Application Ref: H23-0720-26

Proposal: **Erection of boundary fence with screen planting (part retrospective)**

Location: **Greystones, Cranesgate South, Holbeach St Johns, Spalding, PE12 8RJ**

Deferral: LCC is not currently in a position to support the application and requests further assessment, supporting evidence, revisions and/or dialogue, as set out in the response.

SITE PLAN 1:250 scale

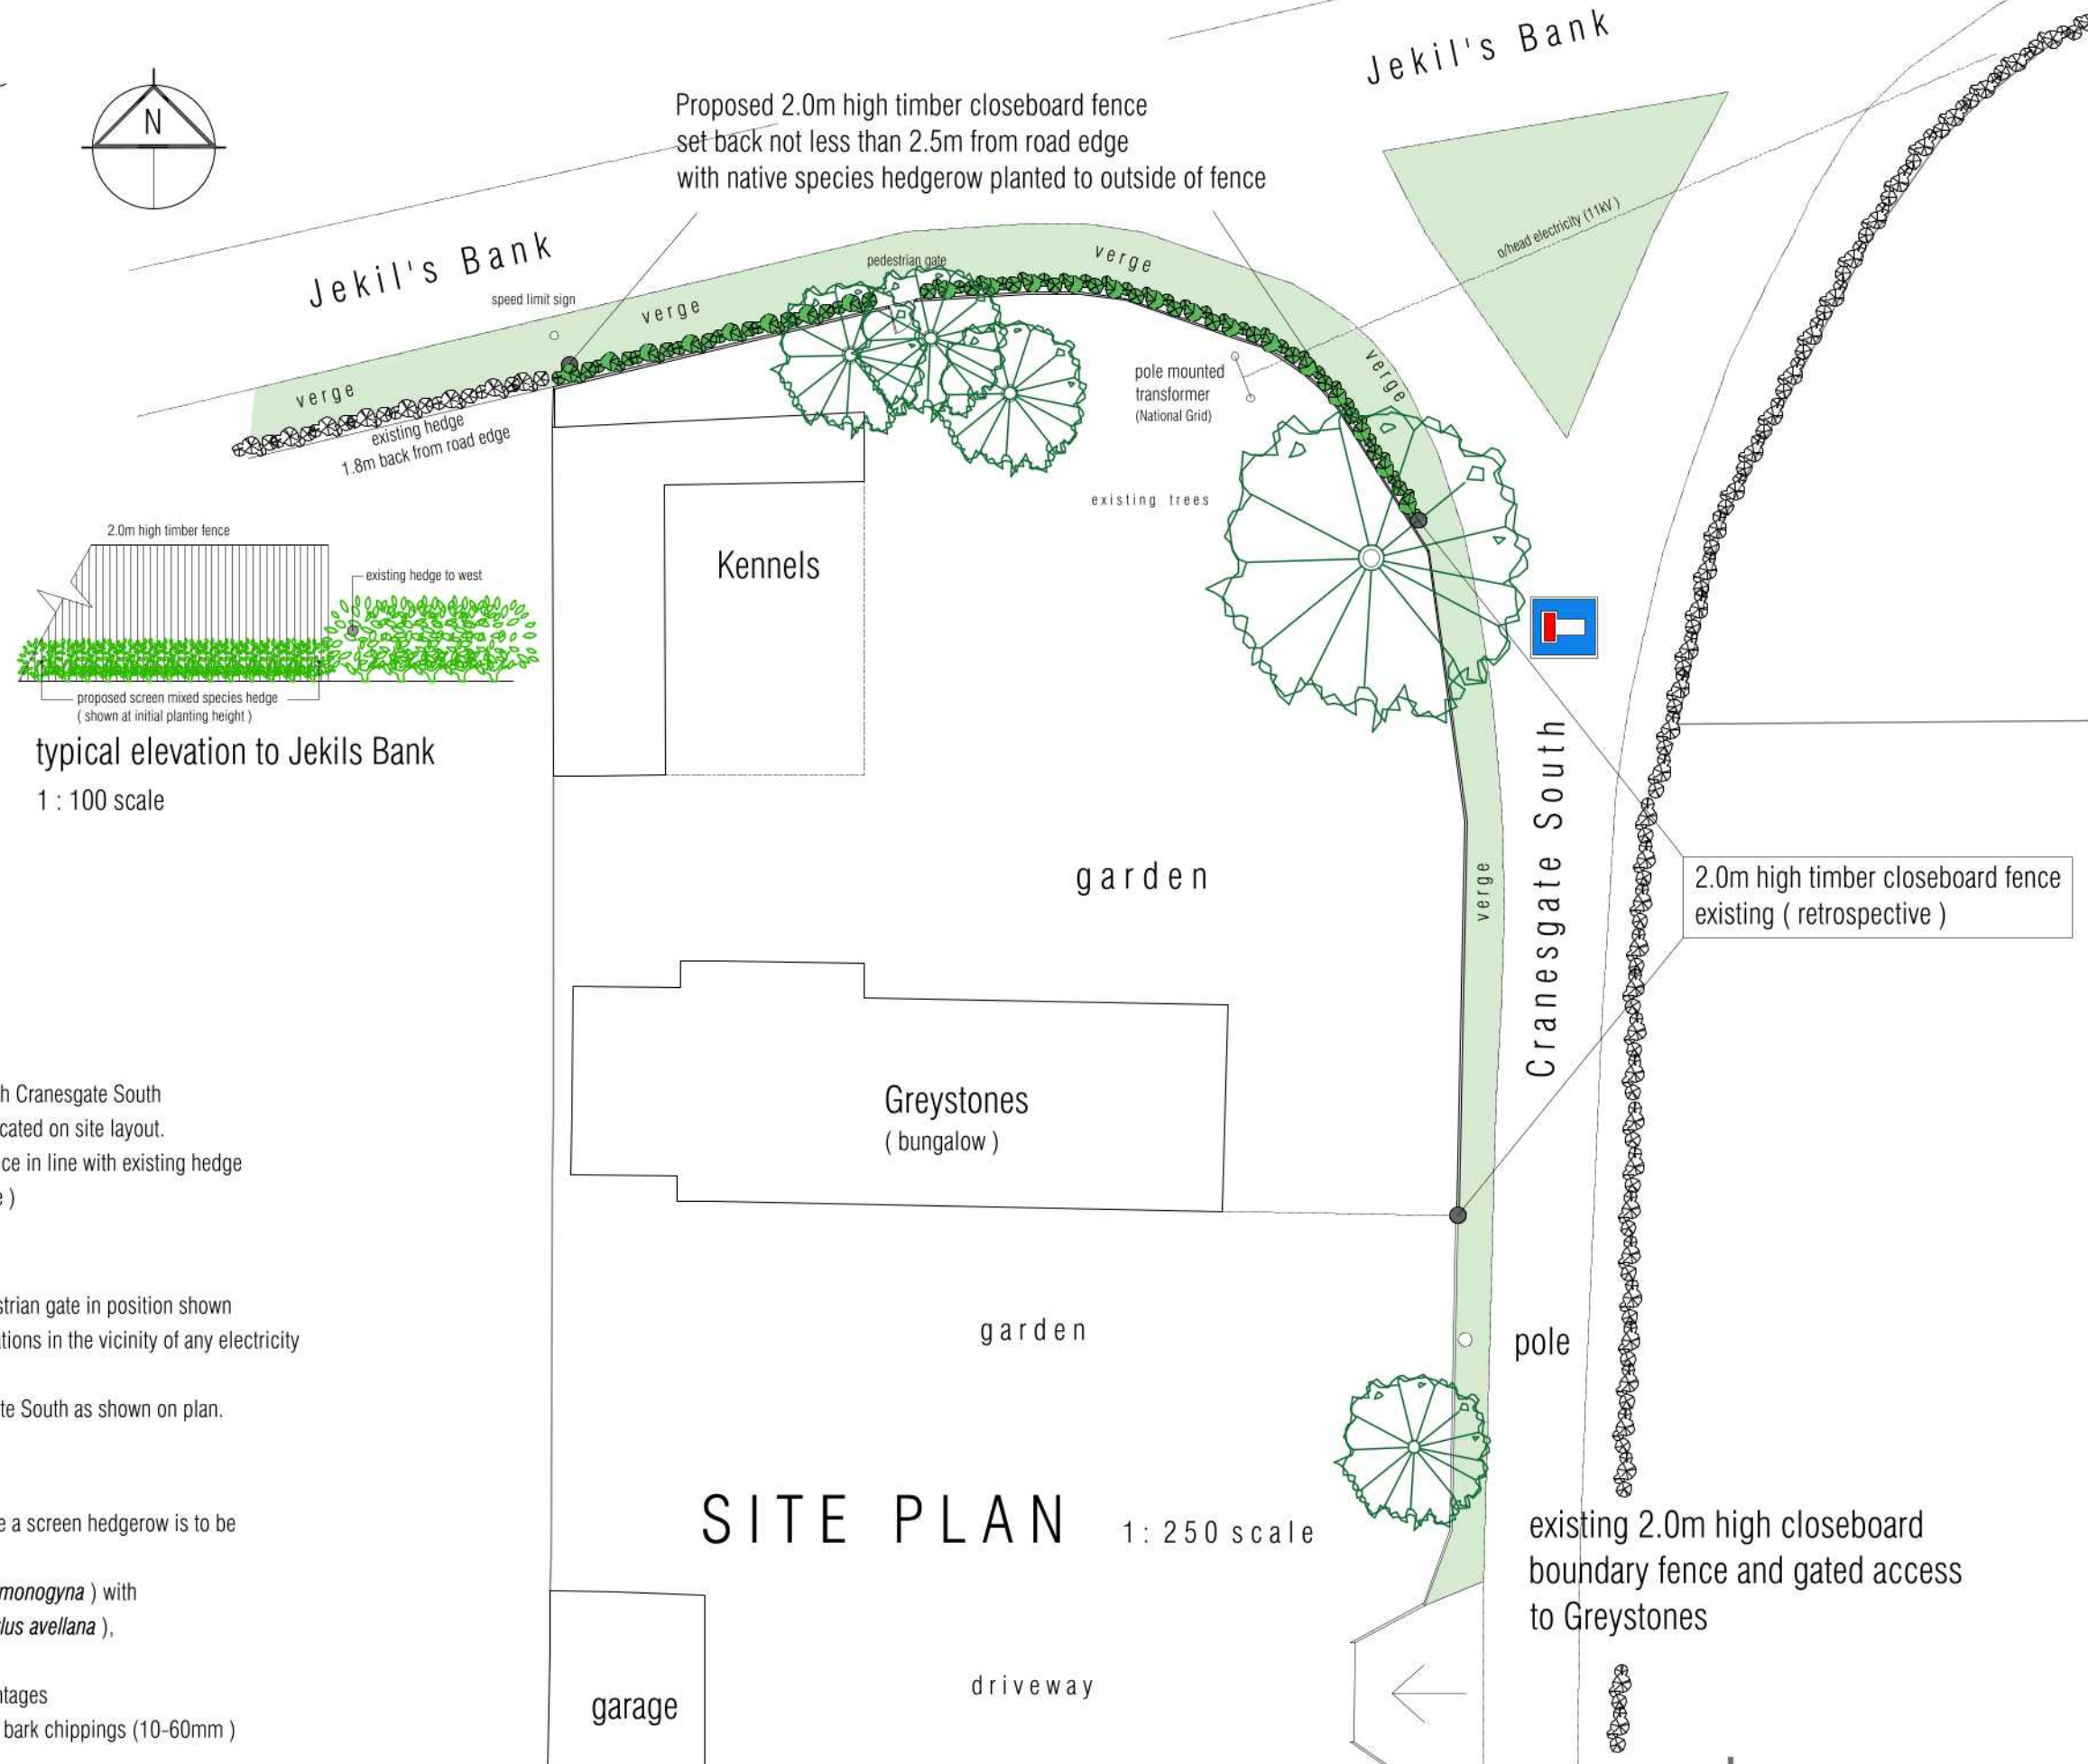
The submitted plans suggest the proposed fence may encroach onto the public highway. The applicant is advised to obtain a Highway Liability Plan from the [Highway Searches Team](#) to confirm the extent of the public highway. If any part of the proposal lies within highway land, the applicant may be required to secure a formal stopping up order under the Town and Country Planning Act 1990 before the development can proceed.

The Highway Authority requests that the above information is submitted prior to determination. Once the extent of the public highway has been established and any potential encroachment issues addressed, a formal response on the proposal can be provided.
